WESTGATE, KEMPS CREEK (SSD-23480429) | INTERIM RESPONSE TO SUBMISSIONS

DEPARTMENT OF PLANNING, HOUSING AND INFRASTRUCTURE

WESTGATE KEMPS CREEK ROADWORKS PLAN

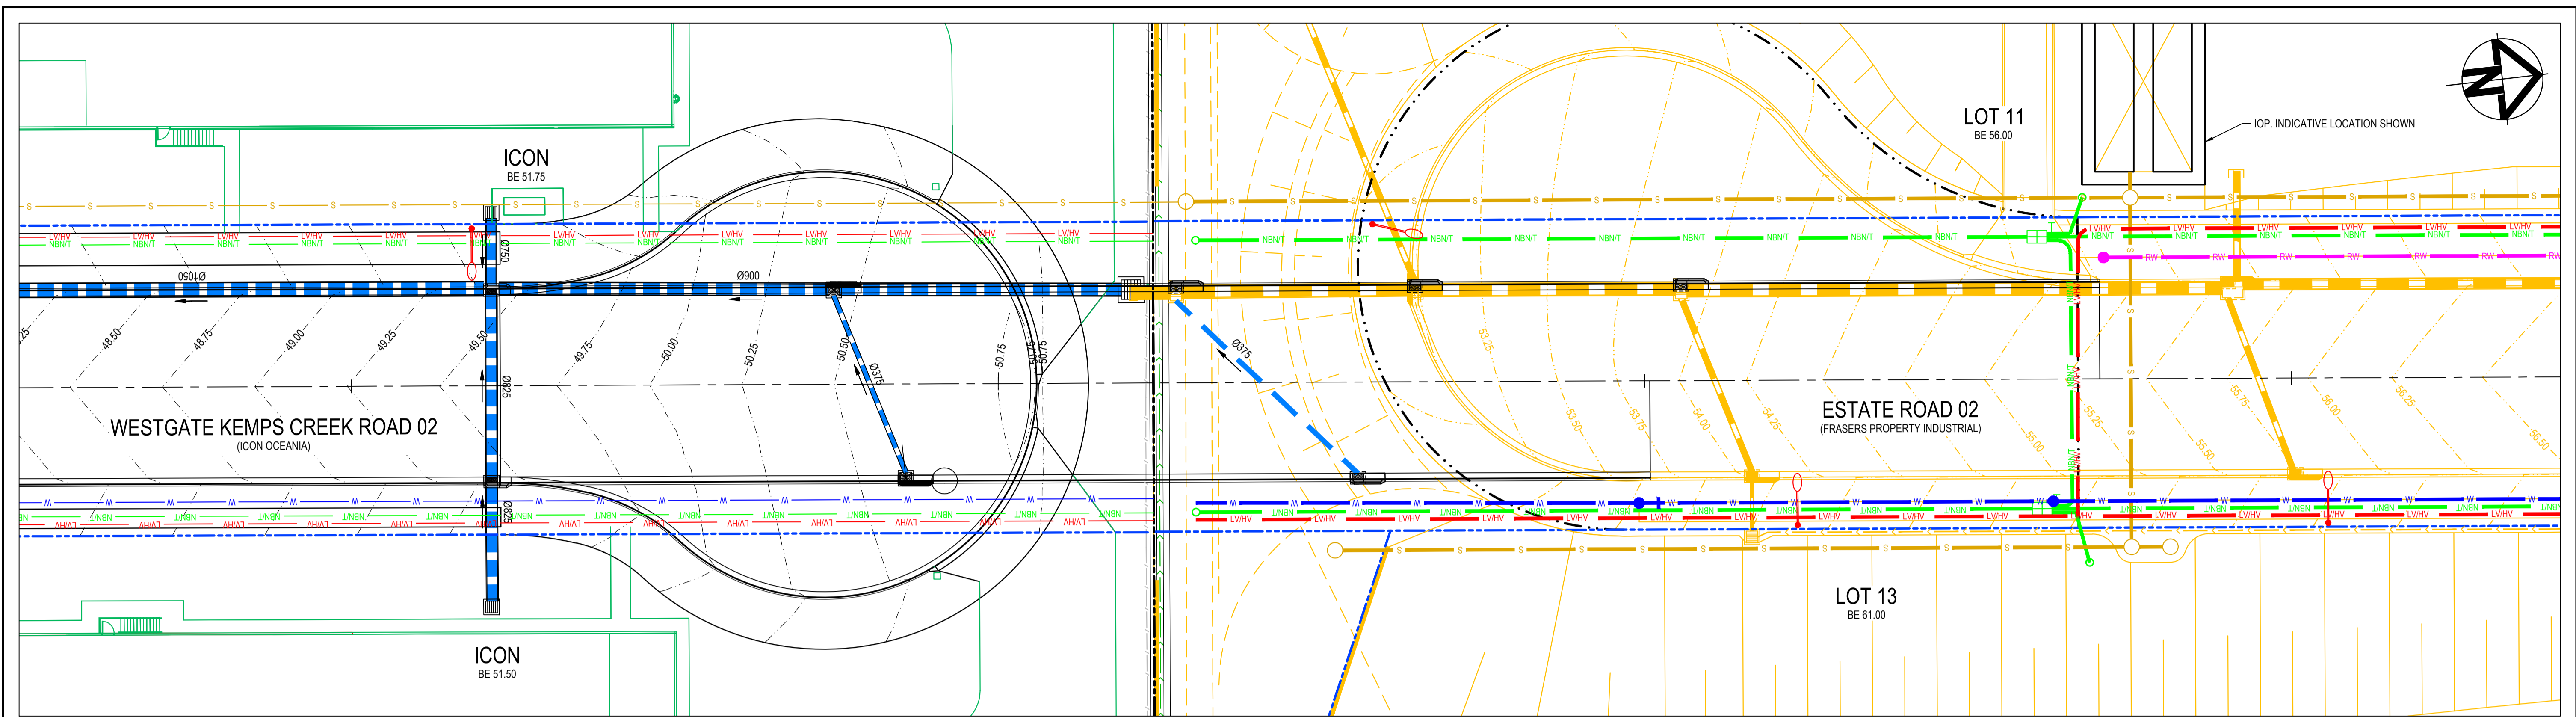
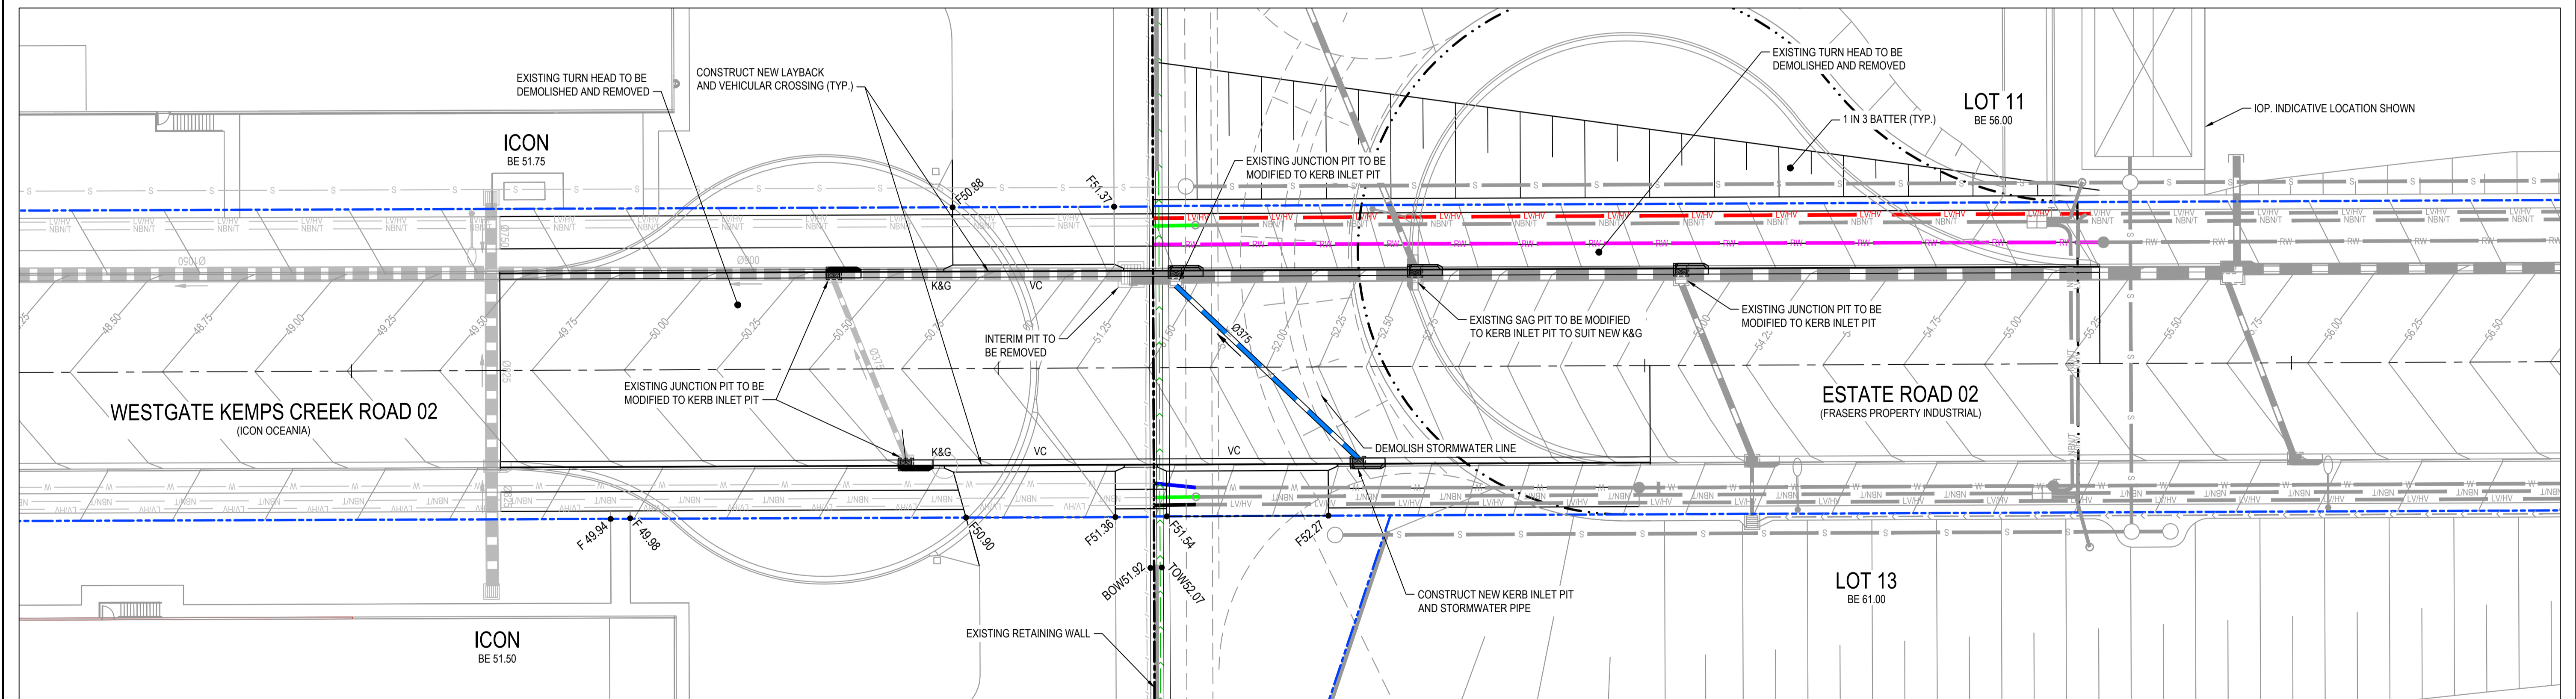
2	<p>Further information is required to understand the coordination and delivery of the road connection linking Road 2 with Frasers' North South Access Road. Please provide the following:</p> <ol style="list-style-type: none"> Details of how the road connection is proposed to be delivered and coordinated between the two parties, including staging / sequencing of works and timing for delivery and dedication to Penrith City Council. Further detail of the levels of the Road 2 / Fraser's North South Access Road connection. Civil Sheet 21-860-C016 shows a section plan from within the vicinity of Road 2 with a potential 10 metre (m) ground level difference between the two sites (Section 4, shown below). Please provide a cross section at this location to demonstrate how access to Warehouse 1C will be achieved for the largest heavy vehicle, noting the following: <ol style="list-style-type: none"> road gradients shown in Civil Sheet 21-860-C930 proposed finished levels of Warehouse 1C, 	<ol style="list-style-type: none"> The roadworks on the Edge Estate (Frasers Property Industrial) and Westgate Kemps Creek (Icon Oceania) will be delivered by the proponents' respective civil works contractors to the property boundary between the two development sites. The need for construction of temporary cul-de-sacs will depend on the relative timing of the civil works. At this stage, given the status of the assessment of the respective SSDAs, it is possible that the roadworks will be delivered concurrently, meaning the temporary turning heads would not be required on either site. However, if for some reason the roadworks on one site are delivered in advance of the other, the extents of roadworks delivered first will need to incorporate the temporary turning head. Depending on interim operational and traffic management requirements, the temporary turning the extent of roadworks delivered second may also need to incorporate a temporary turning head. <p>If the timing of roadworks on the two sites does not coincide and temporary turning heads on either site are in place, the completion of the roadworks on the site that comes second will need to include:</p>

Item	Issue	Response
	<p>(iii) proposed finished levels of Fraser's Edge Estate at the southern boundary, and the proposed Lot 14 access roads</p> 	<ul style="list-style-type: none"> - Demolition of the temporary turning head on the neighbouring site - Extension and connection of stormwater drainage and other utilities (details to be resolved by respective service designers) - Construction of the final roadworks connecting the two sites. <p>It is anticipated that a condition would be incorporated into the consent for Westgate Kemps Creek if Edge Estate is approved before it (or vice versa) requiring details to be provided for the connection of the two roads prior to the issuance of a CC or SWC.</p> <p>If the roadworks on the site completed first have been dedicated to Council, it is envisaged that the connection works would be subject to a Section 138 (Roads Act) Approval. If the roads are yet to be dedicated to Council, it is envisaged that the connection works could be completed under a SWC.</p> <p>(b) Please refer to the revised drawing 21-860-C930[B] (Attachment A, in Appendix A), in that shows the proposed road design joining Road 02 between Edge Estate and Westgate Kemps Creek Additional details have been included in this drawing, including proposed road contours and levels at the property boundary at the driveways into Westgate Lot 1C and Edge Estate Lot 14.</p>
